1st May 2026

Our reference: RM-6.2

Re: AL/20/26/PL Demolition of existing tennis court and erection of a commercial building (within Use Class E(g), parking, landscaping and other associated works (resubmission following AL/107/25/PL). This application is a Departure from the Development Plan, may affect the character and appearance of the Norton Lane, Norton Conservation Area and is in CIL Zone 3 (Zero Rated) as other development. Land At West Barn, Old Dairy Lane, Norton PO20 3AF

**PROPOSED DRAINAGE LAYOUT**  
SHEET 1 of 2

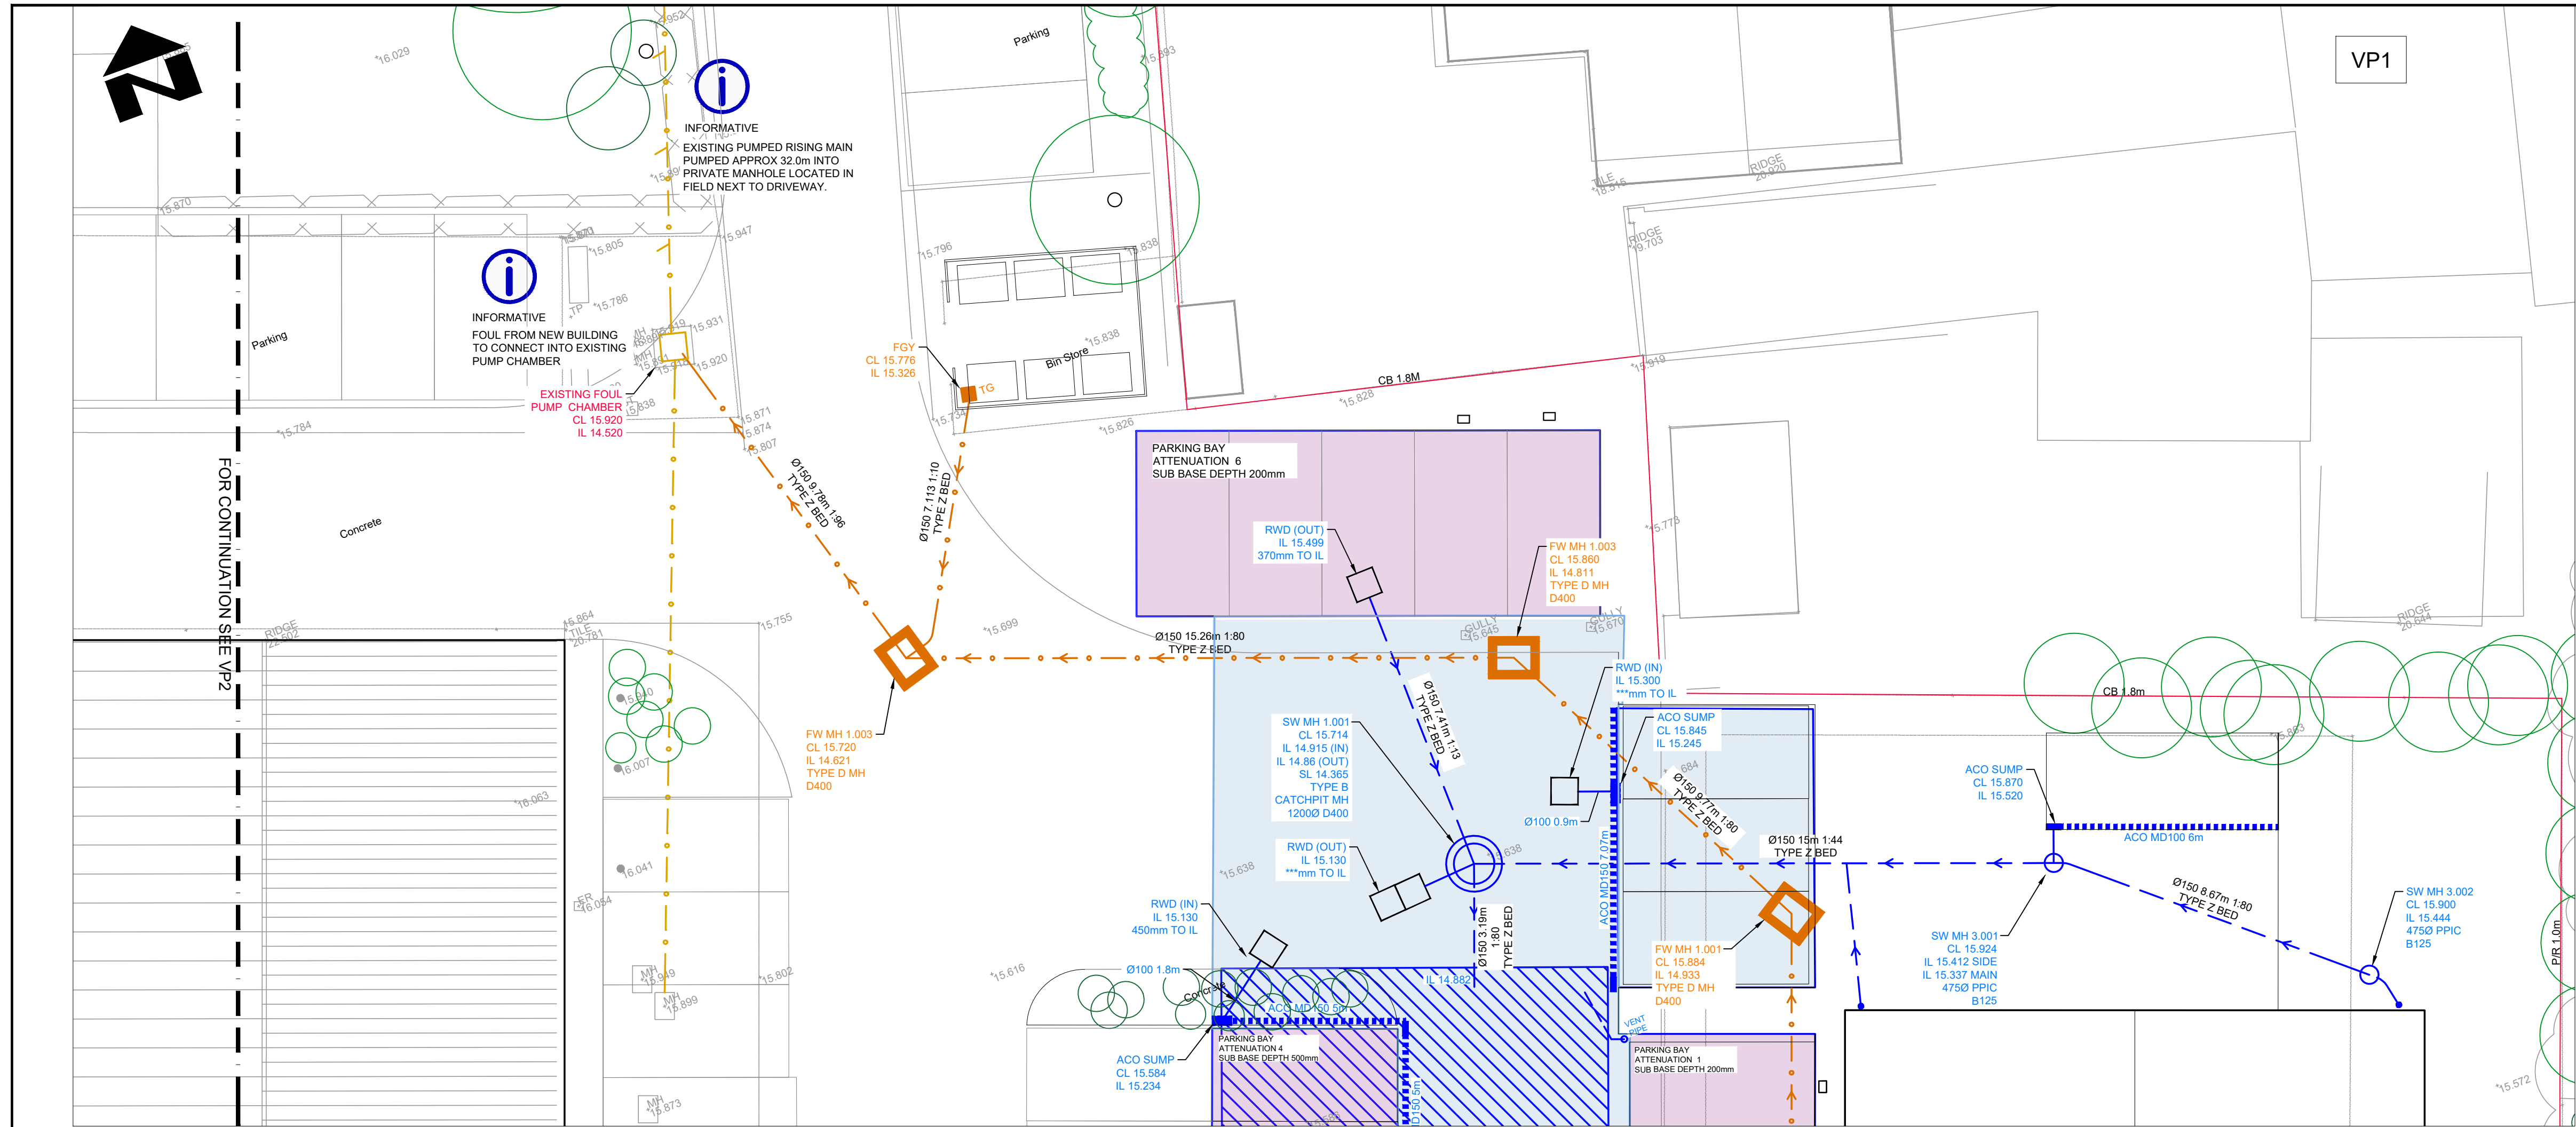
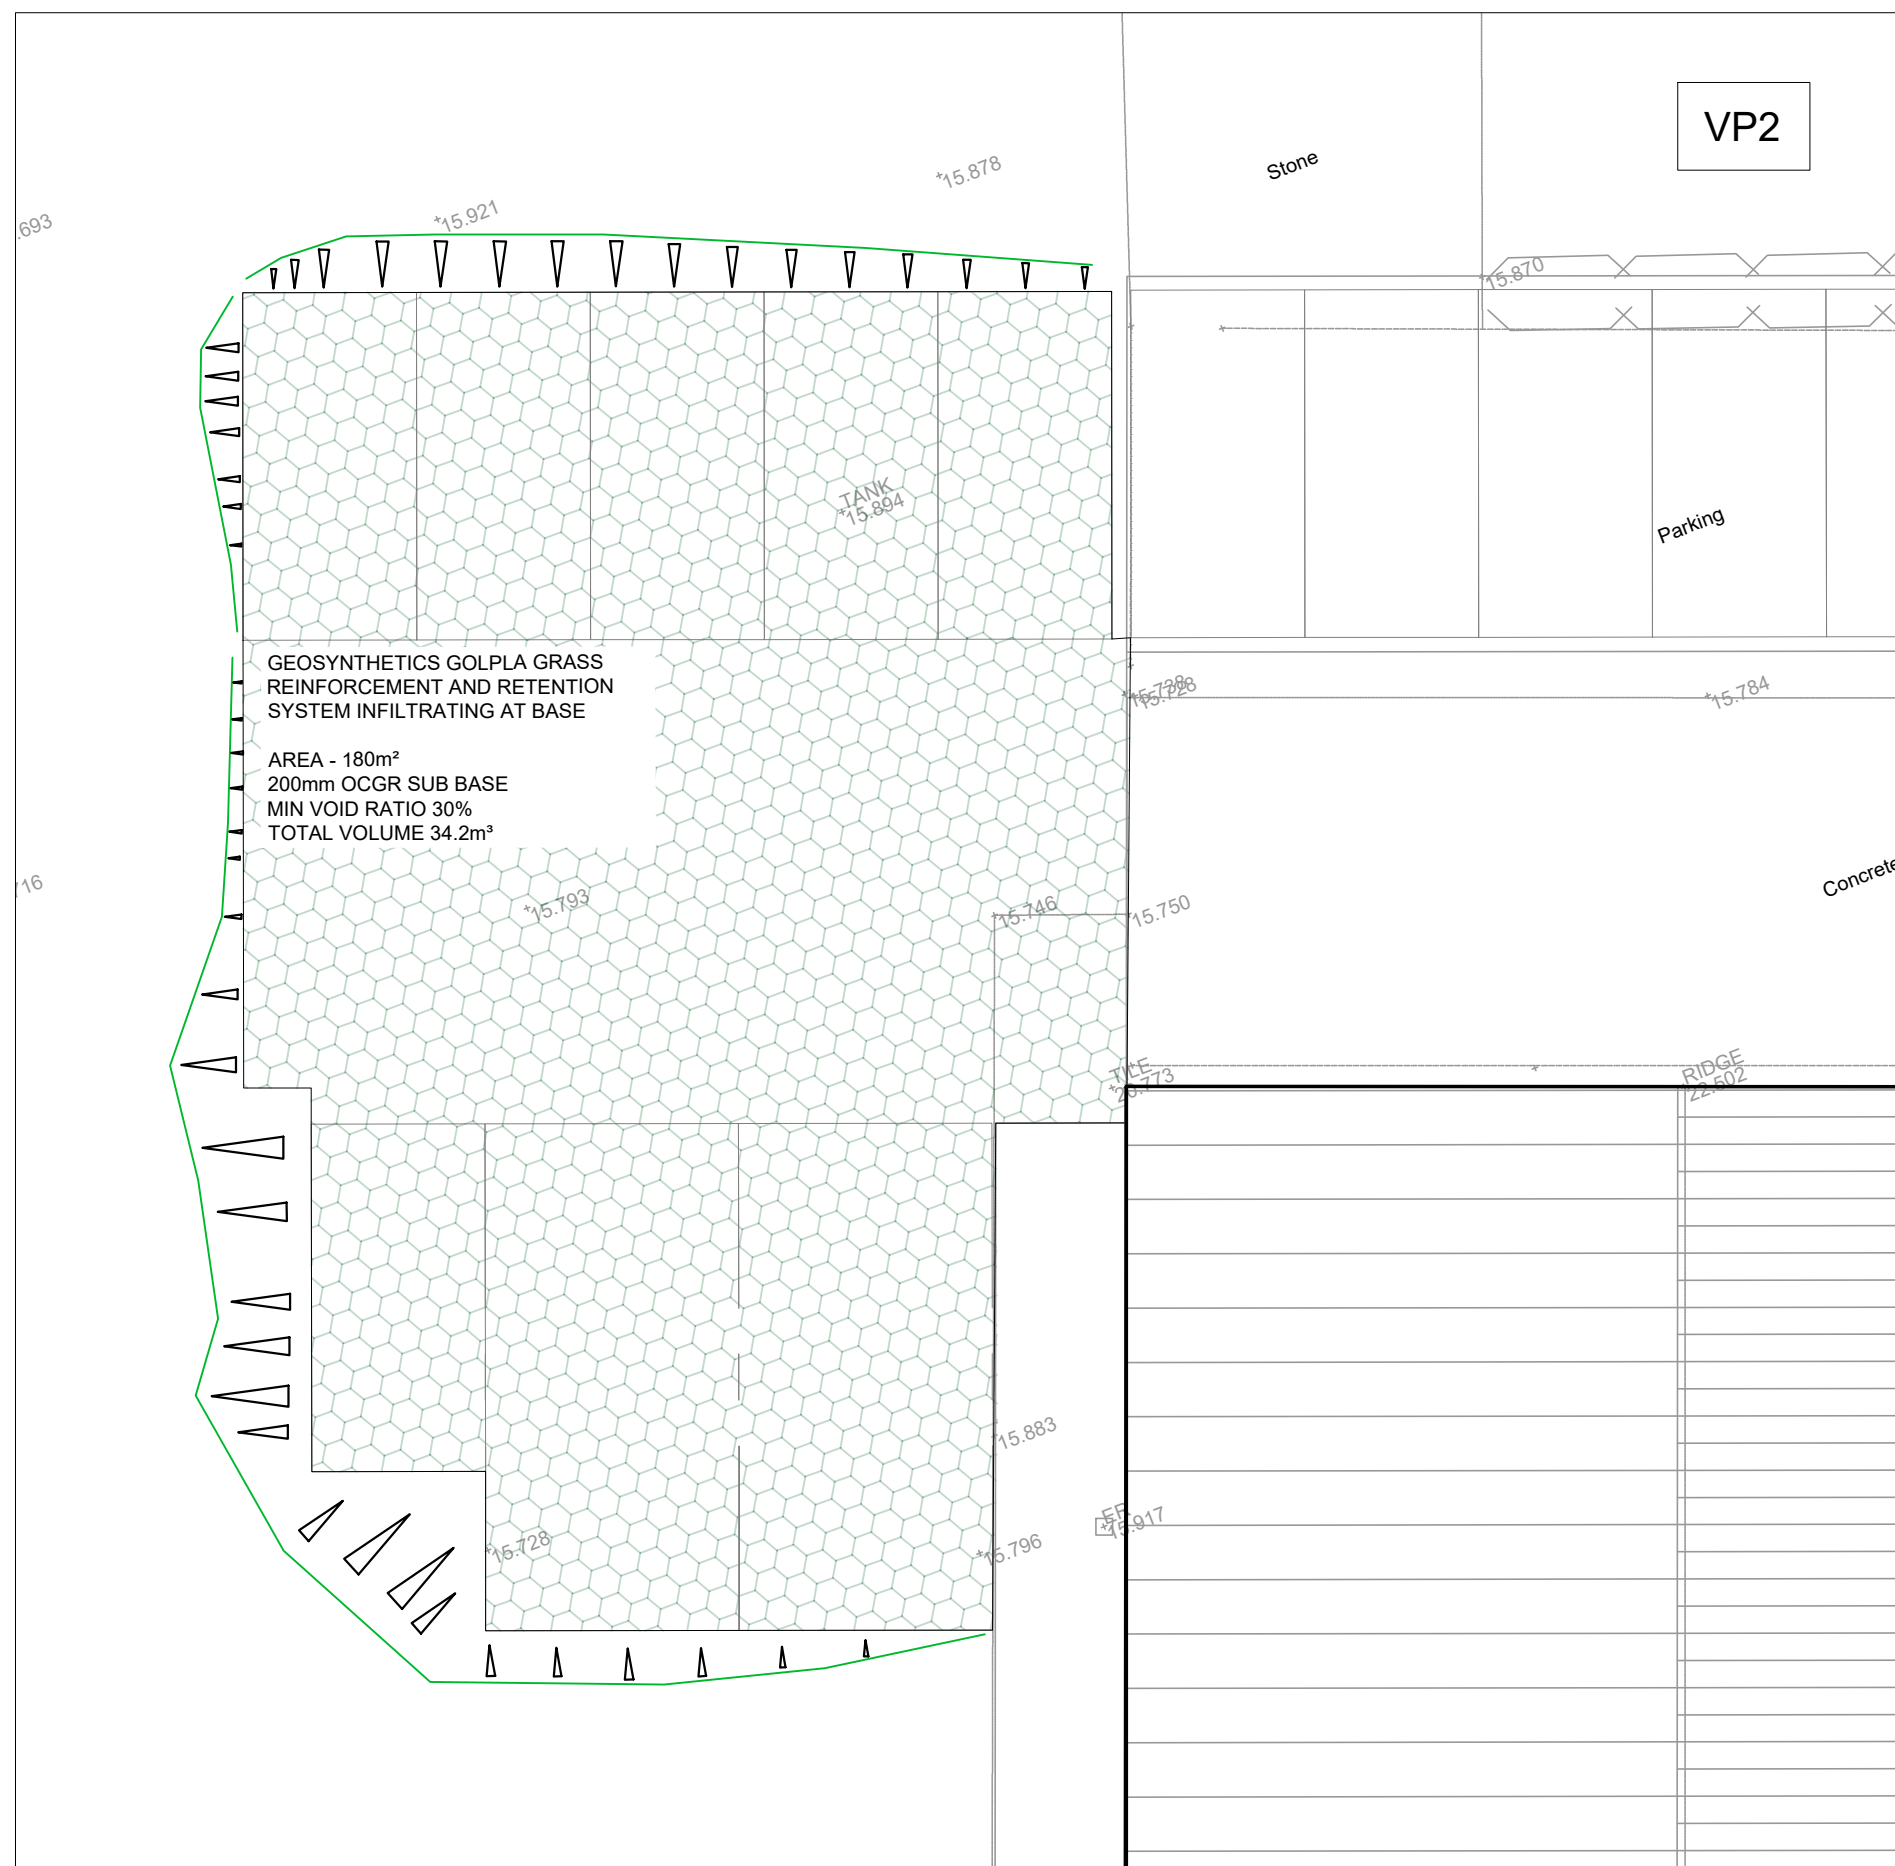
Our client notes and fully supports the engineers’ comments on, and objection to, the current application. Our client is very concerned that the applicant has supplied insufficient information in relation to run-off destination, extreme rainfall and flooding. We note that the engineers have also requested further information in relation to interception drainage, water quality, construction and operation, maintenance, decommissioning and structural integrity.

We note in an email to the agent, the Council Planning Officer has said that the site falls into a small site exception in relation to SuDs. The existing tennis court has a permeable surface, and the replacement building will not be permeable; we disagree that the site falls within the small site exception. The application should require the normal SuDs information to be supplied to the LPA.
